Our Ref: EN010098

## **Planning Act 2008 (as amended) – Section 51**

### **Application by Ørsted Hornsea Project Four Limited for an Order Granting Development Consent for the Hornsea Project Four Offshore Wind Farm**

#### **Advice following issue of decision to accept the application for examination**

0 25 50 100 Meters

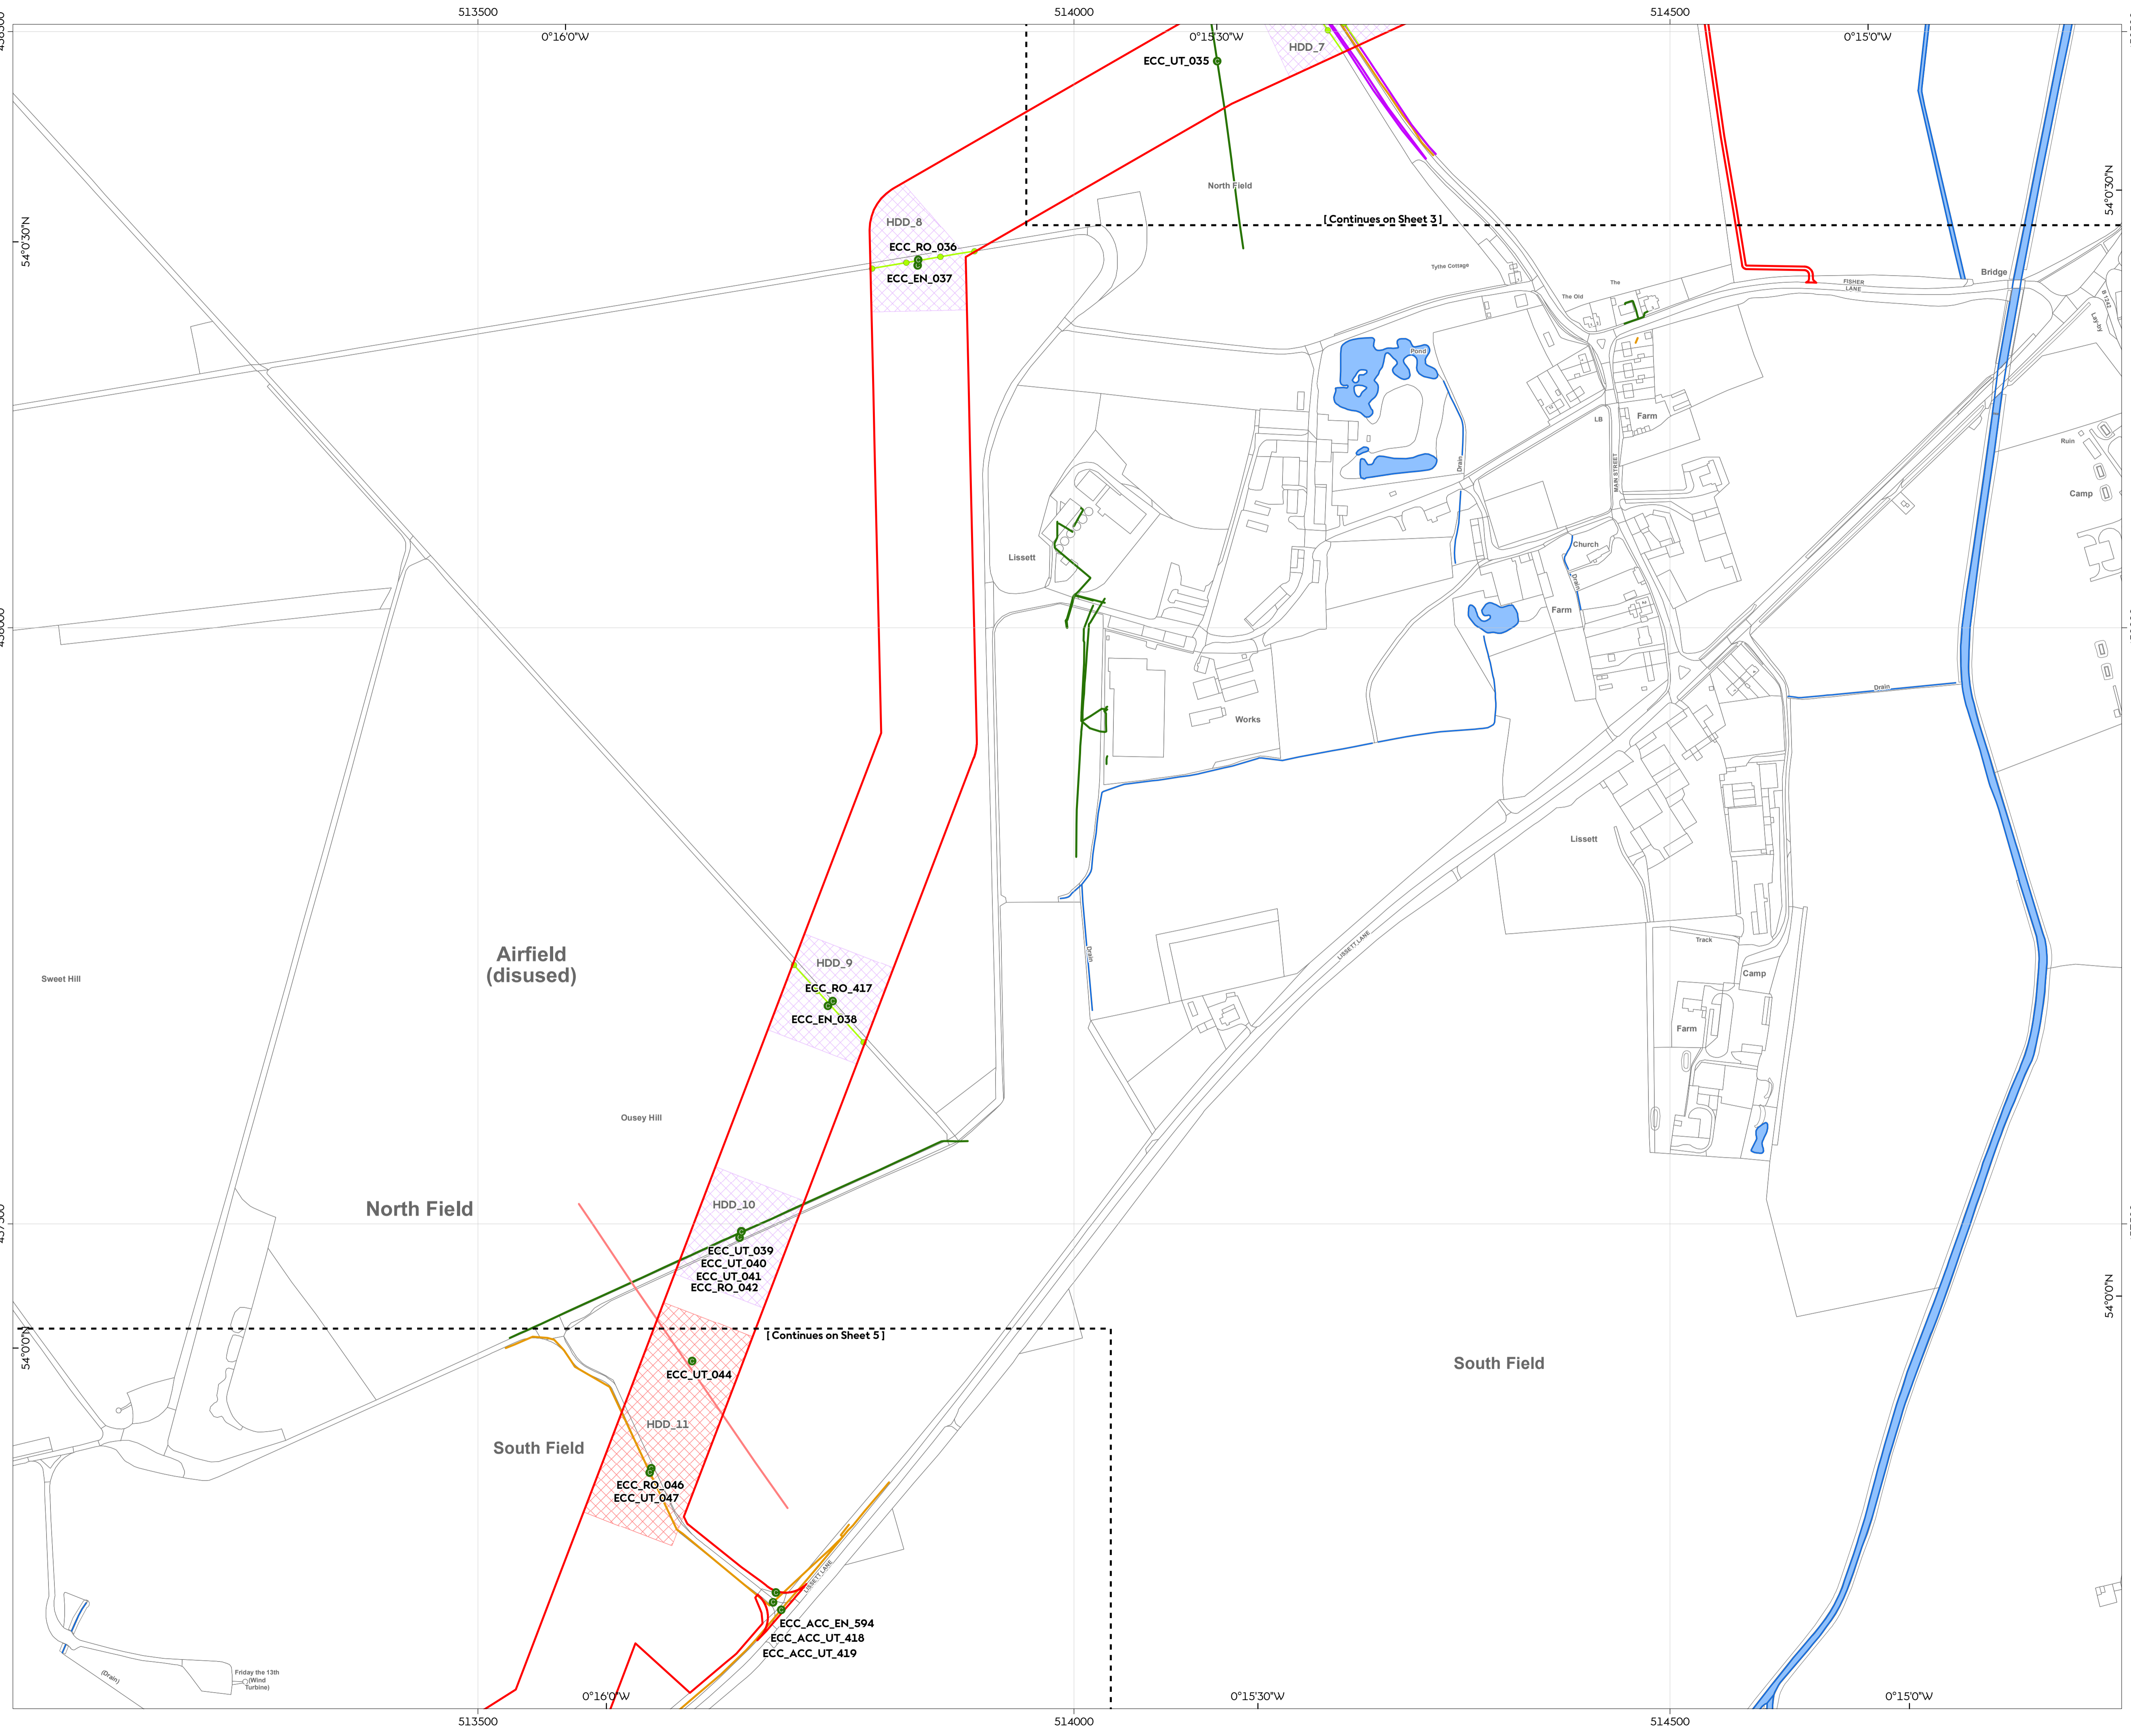
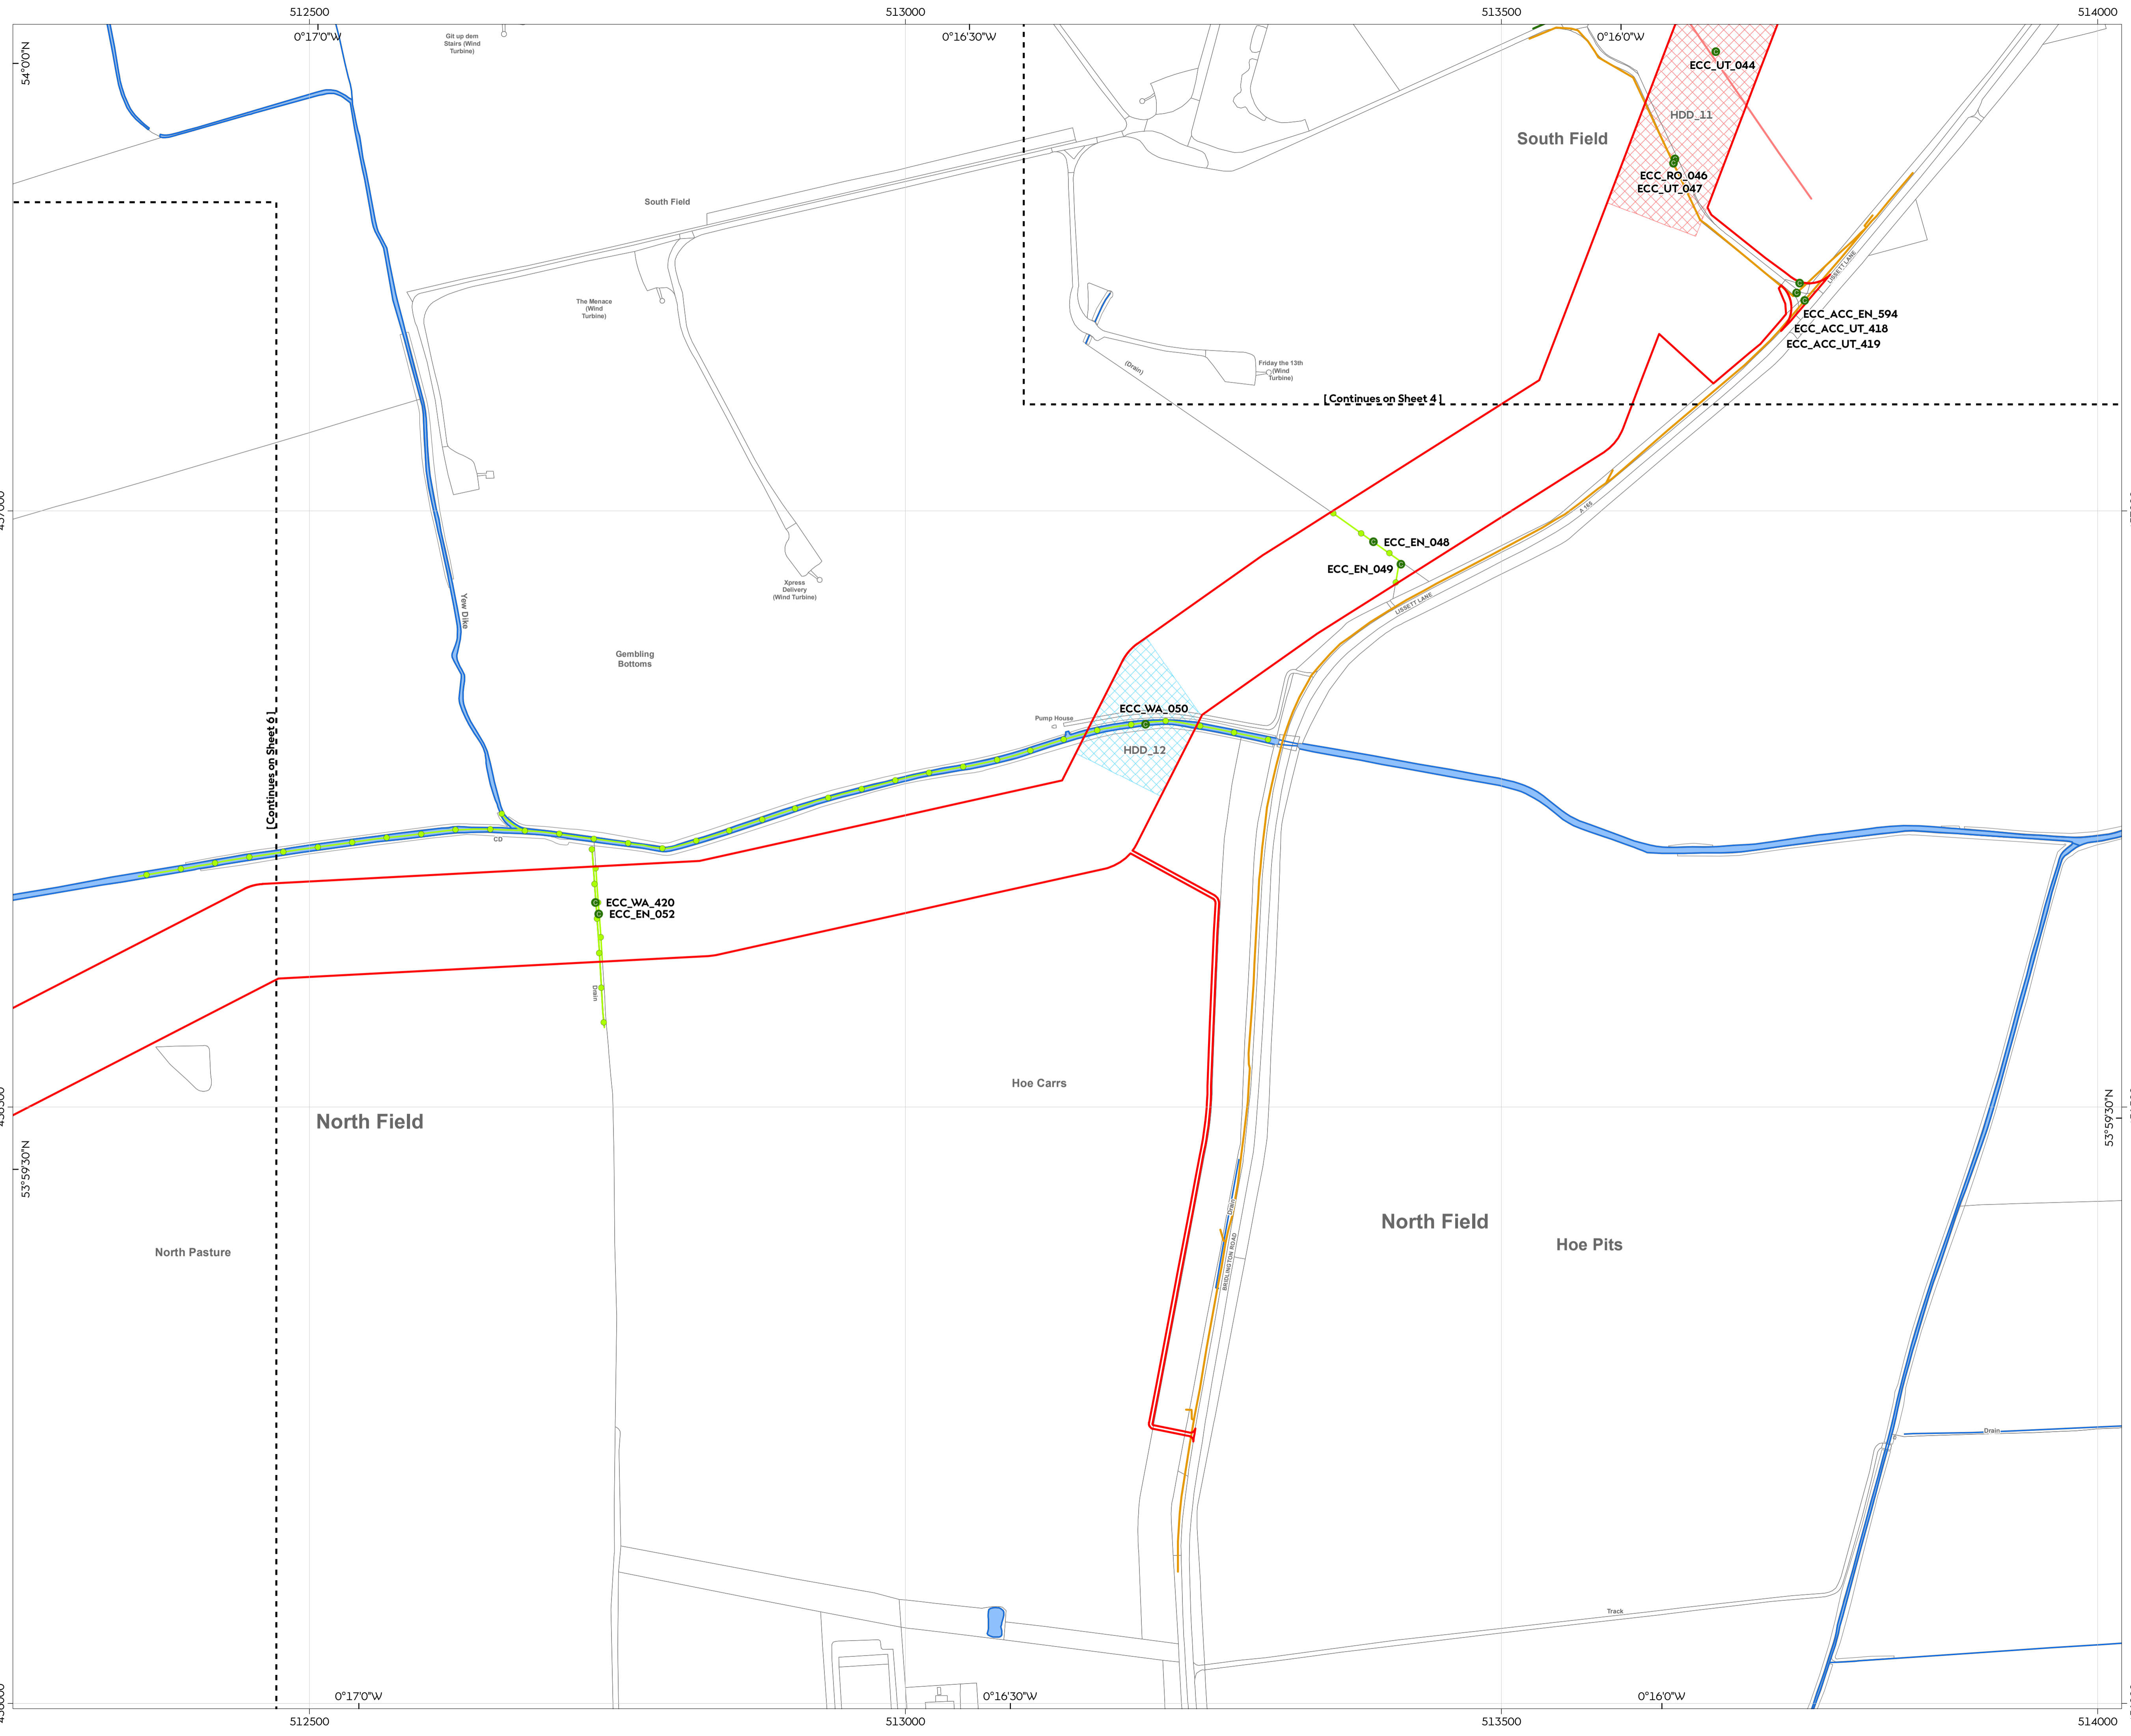
The location of all HDDs is presented in the Onshore Crossing Schedule (Doc A4.4.2). However, this document is not referenced within the draft DCO (Doc C1.1). If HDD is proposed to mitigate any environmental effects the Applicant is advised to ensure that its delivery is secured.
